Boston Alternative Energy Facility

The Applicant's Comments on Lincolnshire County Council's Local Impact Report

Document Reference: 9.23

Date: 11 November 2021

BOSTON ALTERNATIVE ENERGY FACILITY DEVELOPMENT CONSENT ORDER
 Regulation 5(2)(k) - Access and Rights of Way Plan
 BOSTON BOROUGH COUNCIL
 Sheet 1 of 1

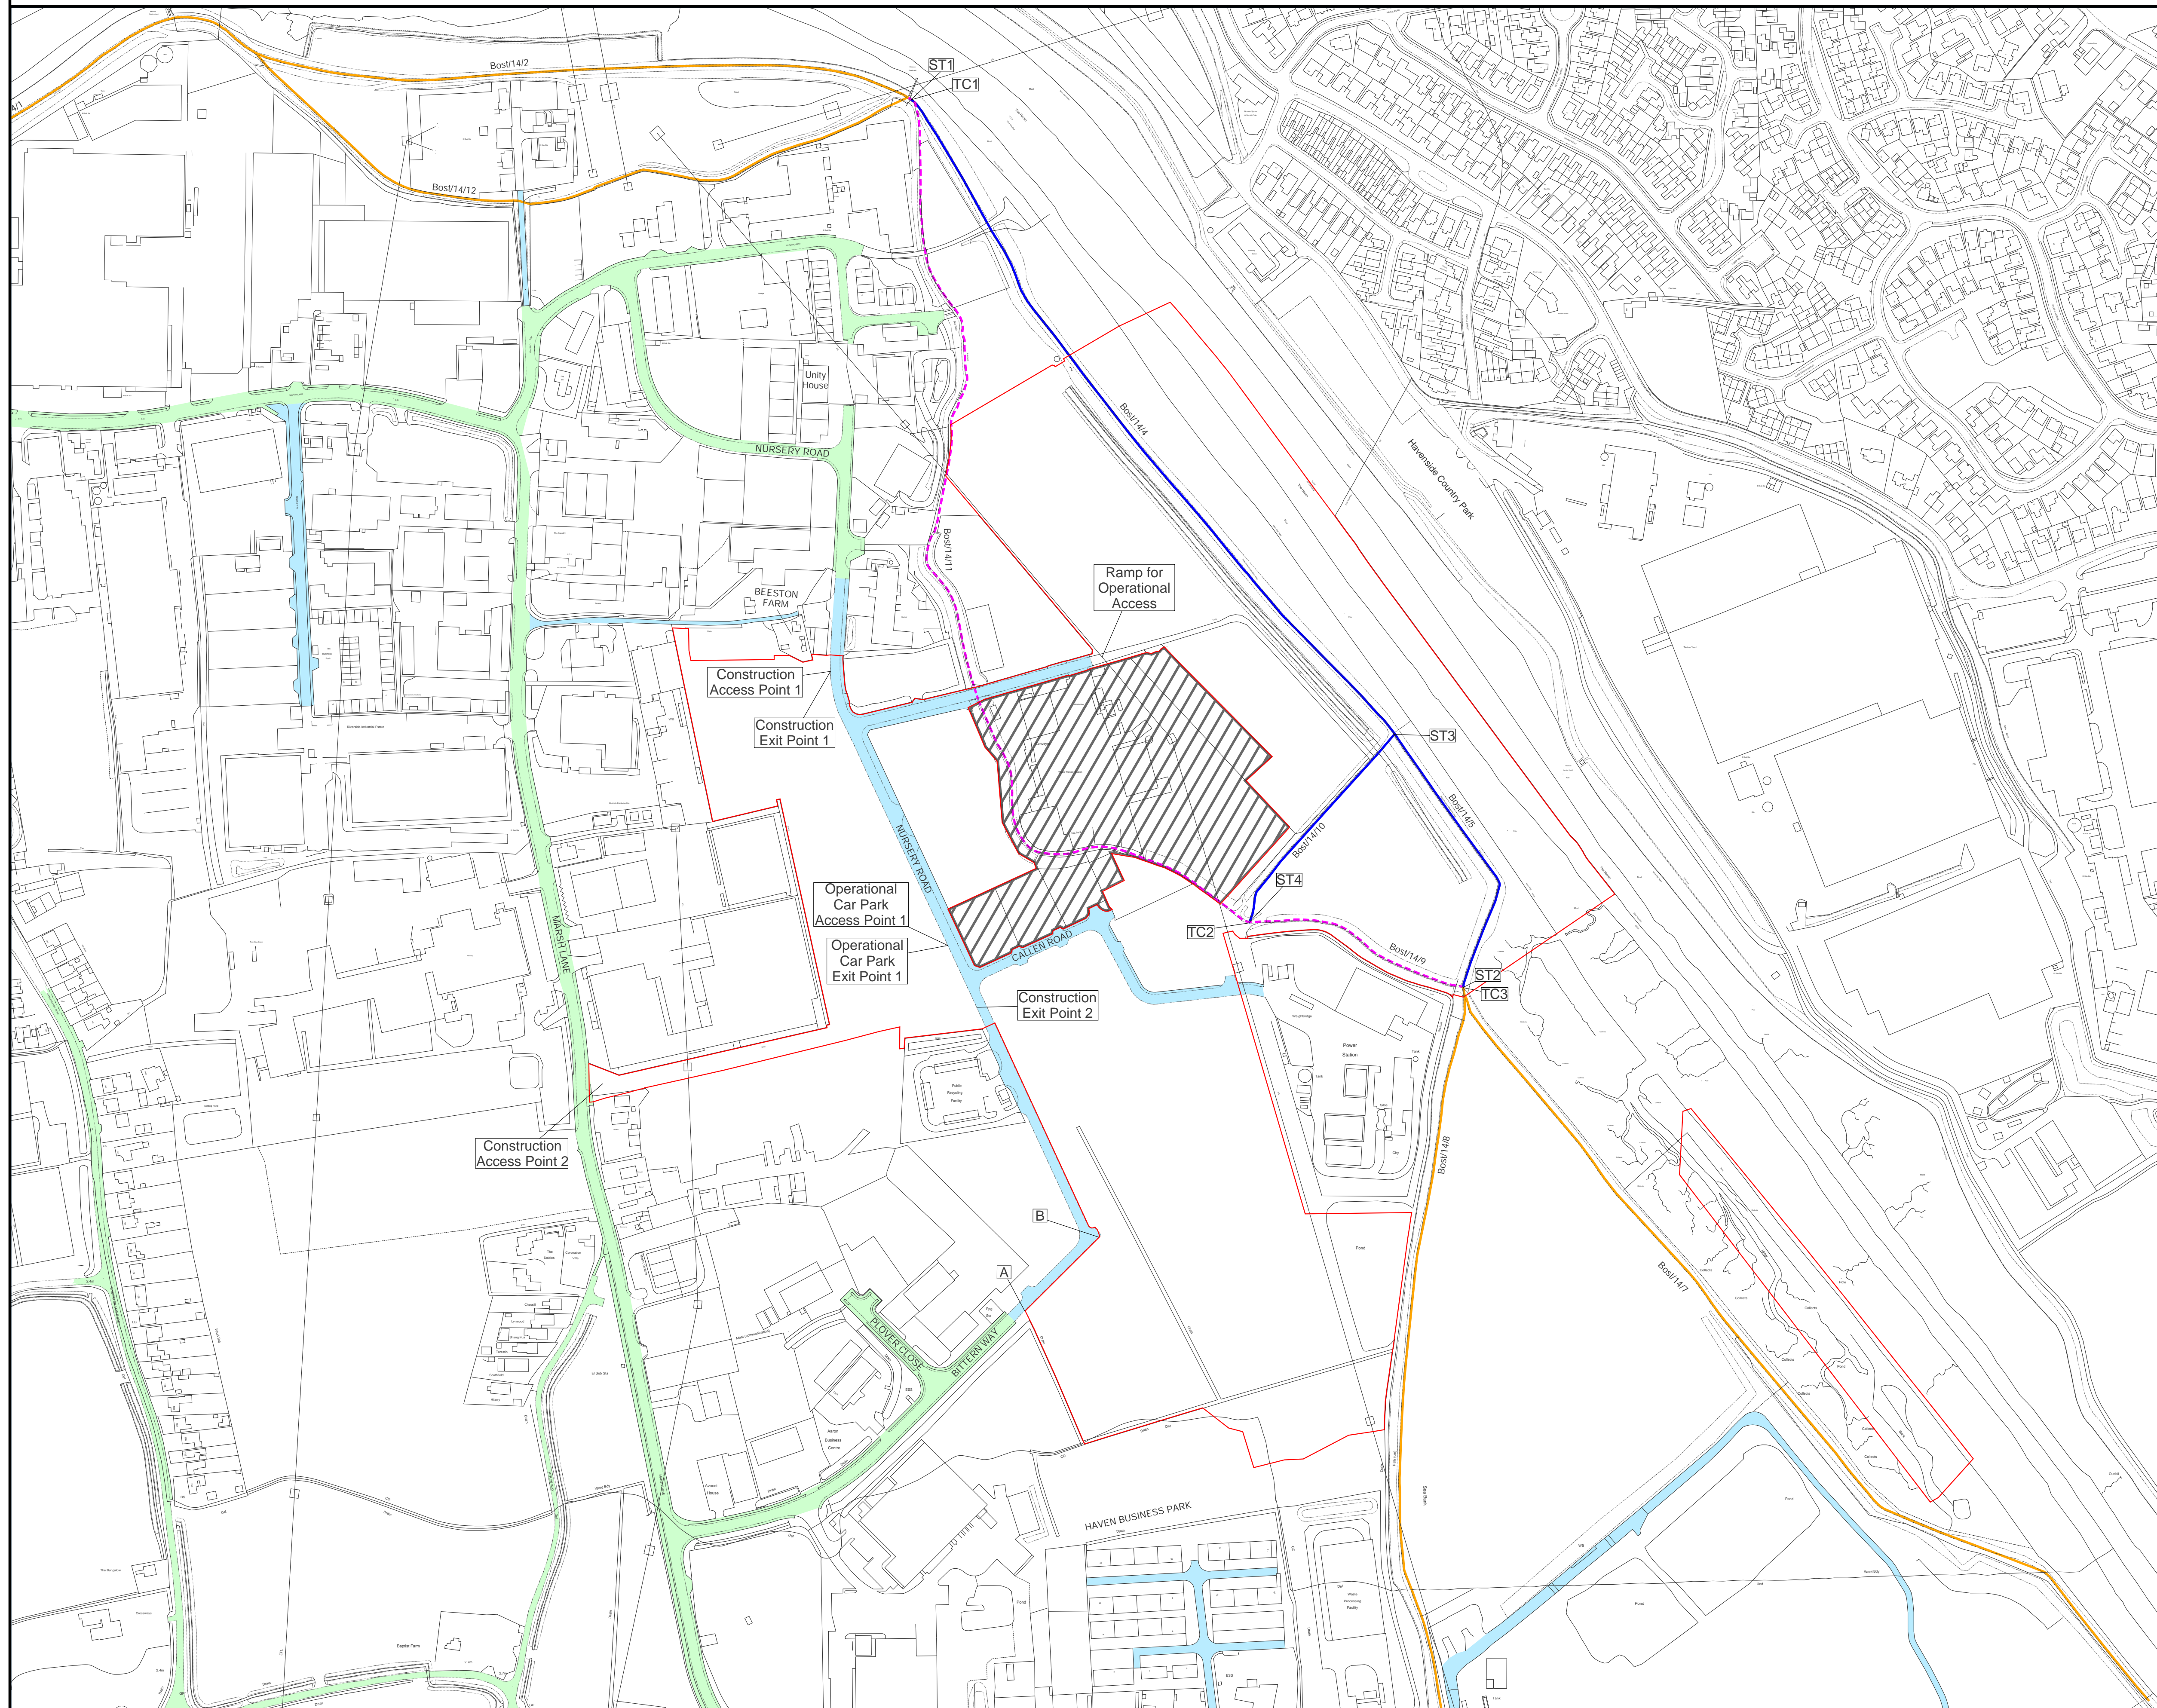
6.3.2	There is a net loss of approximately 1 km of public rights of way across the scheme with no indication of any specific mitigation to offset this loss. It is suggested that it may be a prudent opportunity to undertake improving the rights of way from London Road to Lealand Way (Boston PF14/1 and 14/2) for them to be created as cycleway /footway and appropriately surfaced to provide safer commuting access to the Industrial Estate and recreation purposes which could be secured by an appropriately worded requirement or Planning Obligation.	<p>Please see the Applicant's comments in Rows 18 and 19, Table 1-18, of the Applicant's Comments on Relevant Representations (document reference 9.2, REP1-035).</p> <p>The Applicant is in the process of preparing a PRoW Design Guide which will be submitted to the examination at Deadline 3, which recognises the importance of maintaining the connectivity of the path network in the vicinity of the Facility and presents measures to help mitigate the effects of proposed footpath stopping up. Measures relating to the stopping up of the PRoW will be set out in this document.</p>
